Our reference: ECM 9503846
Contact: Gavin Cherry
Telephone: (02) 4732 8125

1 April 2021

Response to Notice of Exhibition – SSD-10474 – St Marys Resource Recovery Facility at 25 Dunheved Circuit St Marys

PROJECT	25 DUNHEVED CIRCUIT, ST MARYS	
TITLE	SWEPT PATH ANALYSIS - SUBJECT SITE 19m FH13 ARTICULATED VEHICLE

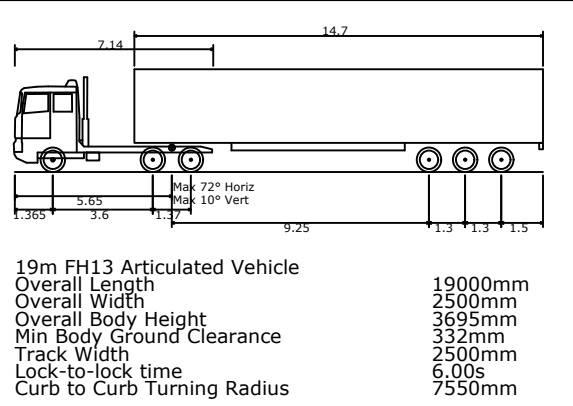
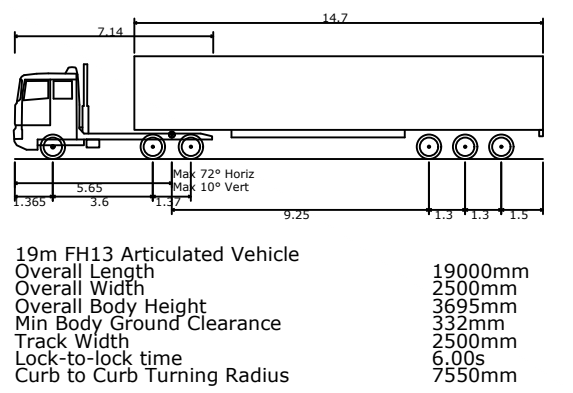
- The development is proposed to be serviced by vehicles only up to 19m in length (no provision for B-Double vehicle movements). B-Double swept paths to/from the proposed access points don't appear to have been provided.
- It is noted that the proposed development will generate approximately half the amount of daily vehicle trips when compared to that of the former

- **Prior to the issue of an Occupation Certificate**, the principal certifying authority shall ensure that a "Restriction as to User" has been created / registered on title detailing that the site is not to be serviced or accessed by any vehicle greater than 19m in length. B-Double vehicles are strictly not permitted for the life of the development. The authority empowered to release, modify or amend the restriction must be the roads authority being Penrith City Council.
